DRB Project Number: PR-2025-020092 Hearing Date: 8-6-2025  
4A1, VOLCANO CLIFFS UNIT 26  
located on VALIENTE between  
PASEO DEL NORTE NW and  
Project: KIMMICK Agenda Item No: 5

**PA-2025-00225 – SKETCH**

**ADDRESS/LOCATION:** All or a portion of: 4A1, VOLCANO CLIFFS UNIT 26 zoned MX-L, located on VALIENTE between PASEO DEL NORTE NW and KIMMICK containing approximately 13.0 acre(s). (C-11)

PASEO AND KIMMICK EAST
ALBUQUERQUE, NM
CONCEPTUAL GRADING
AND DRAINAGE PLAN

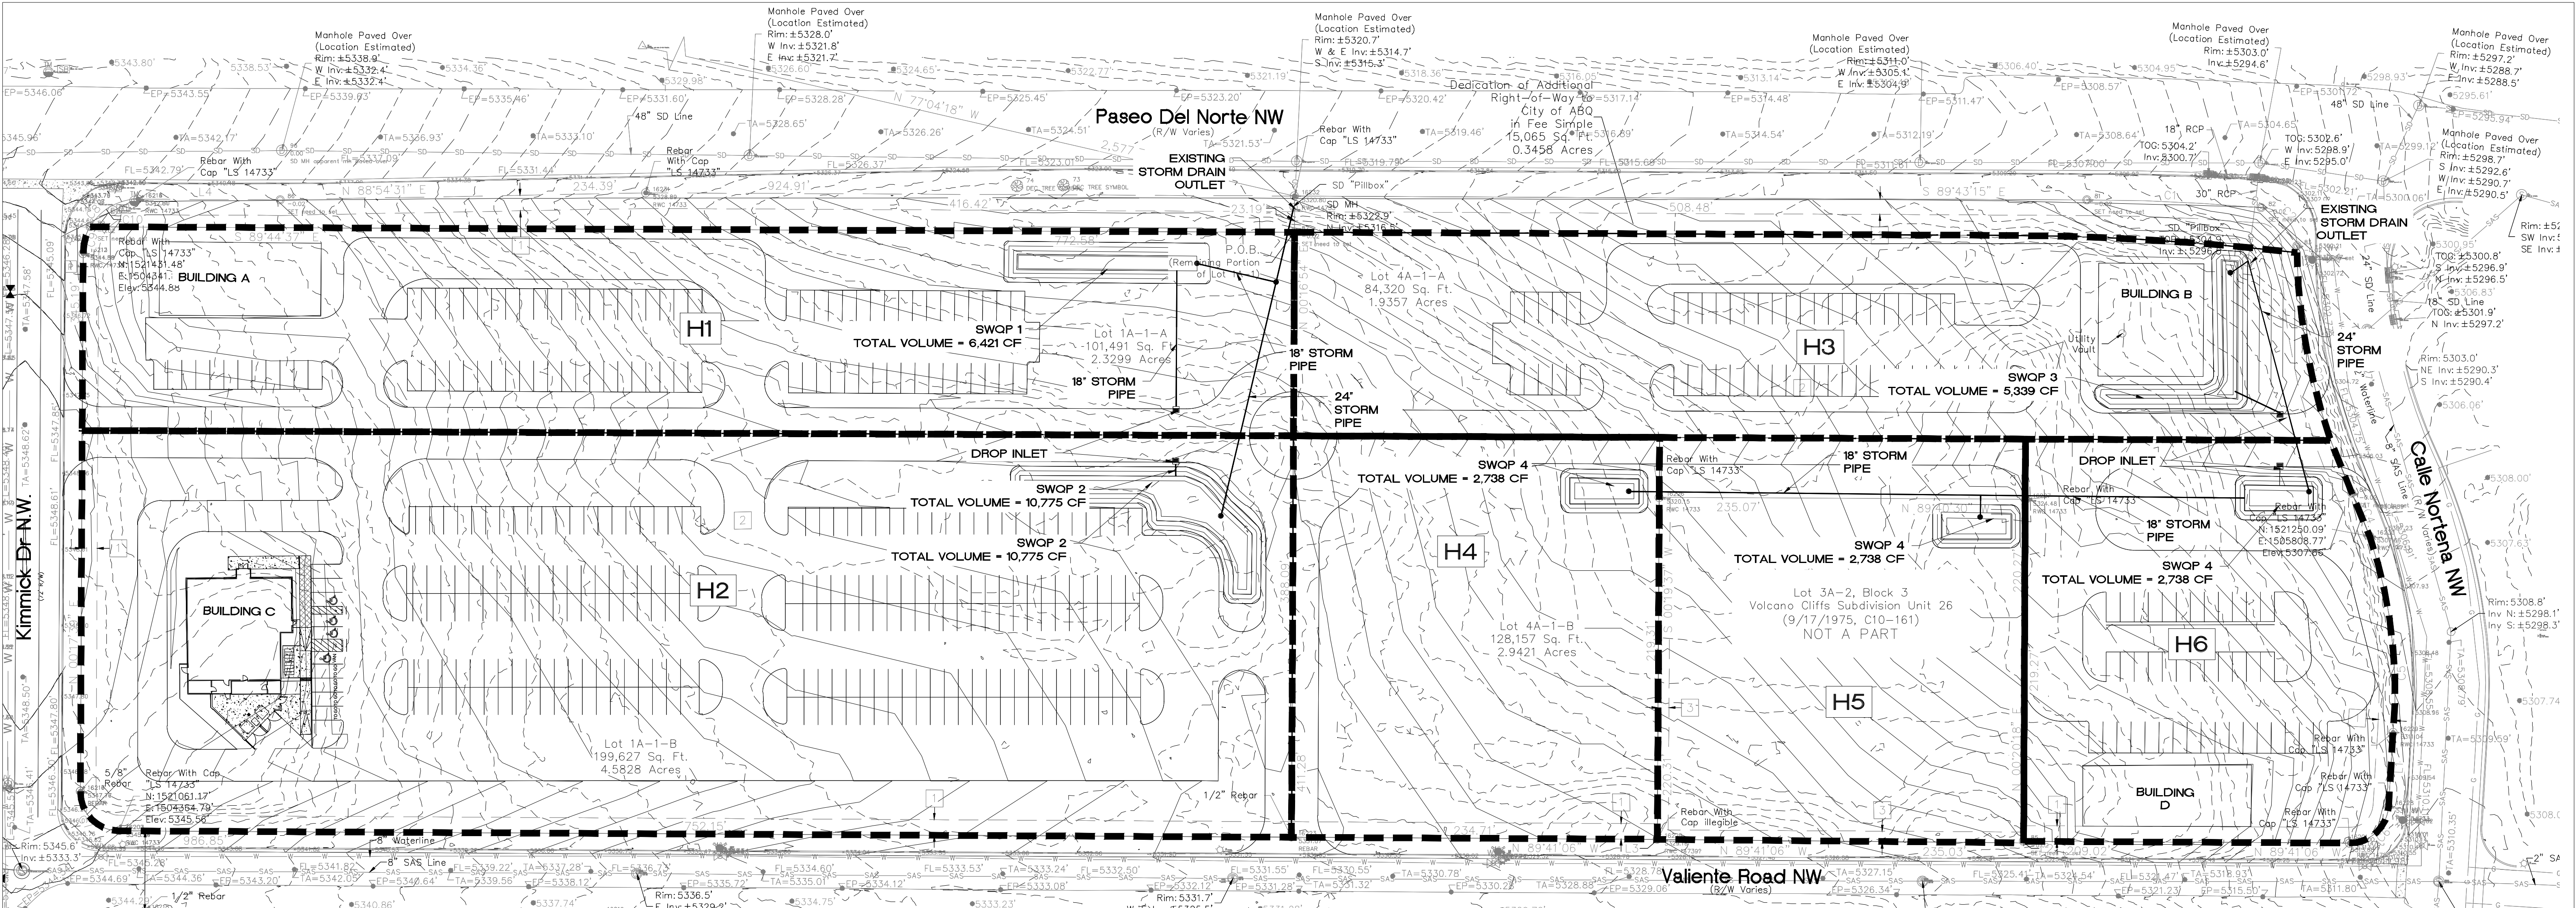
- Hydrology needs to approve the Conceptual Grading & Drainage Plan prior to approval of the sketch plat.
- Comment – Prior to submitting for Building Permit, a licensed New Mexico civil engineer will need to submit a Grading & Drainage Plan to Hydrology for review & approval if one of these conditions is met. (500 cy of grading, 1,000 sf of proposed building, or 10,000 sf of proposed paving).

Purpose of Plat

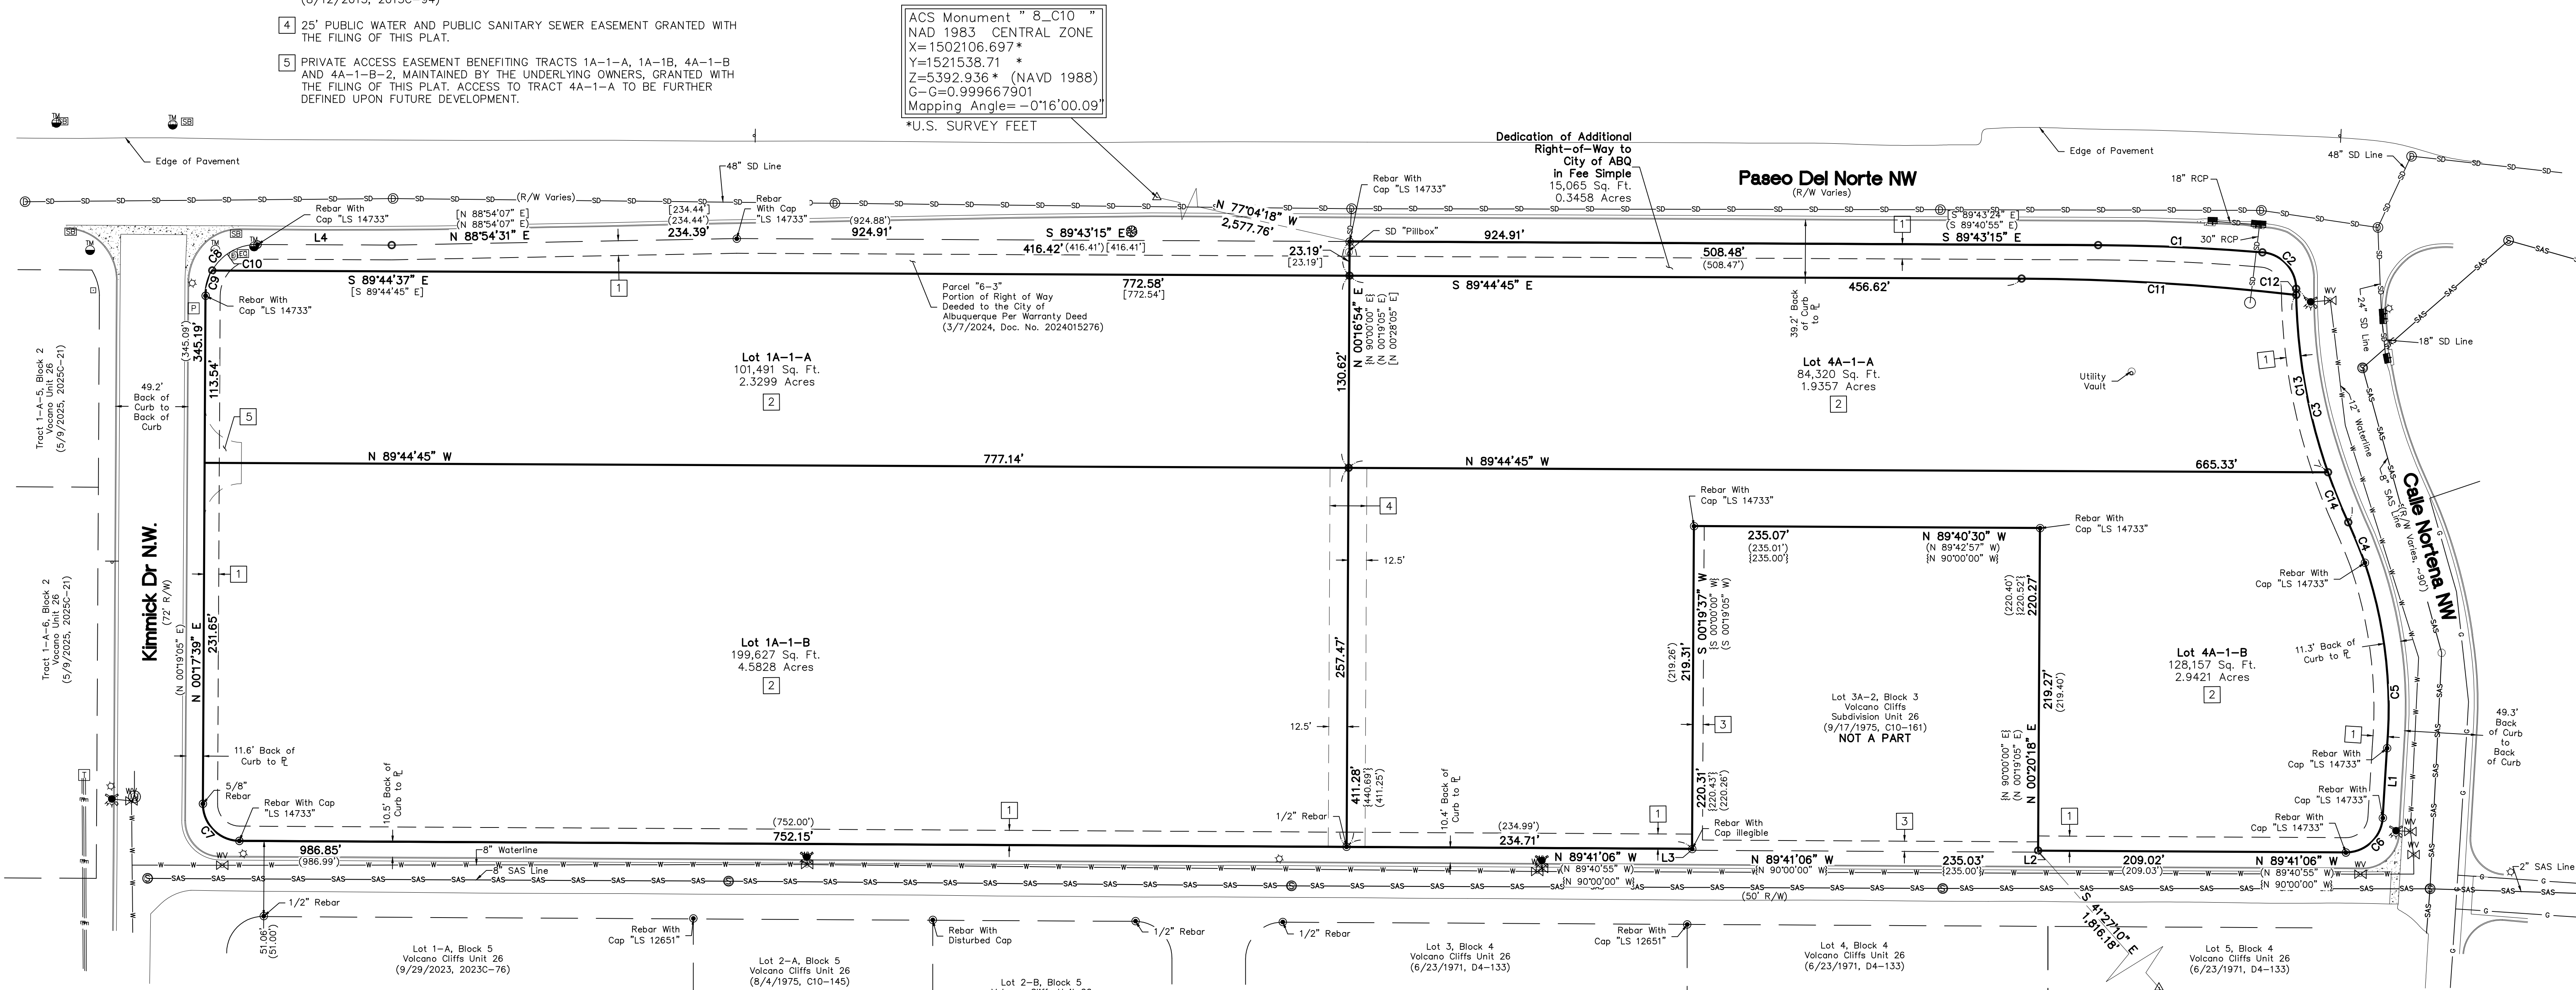
- b. Please provide some fire protection requirements (estimated by a professional or provided by the Fire Marshall's Office).
2. As proposed, Lots 4A1A and 1A1A do not have all frontages with access to both water and sanitary sewer infrastructure.
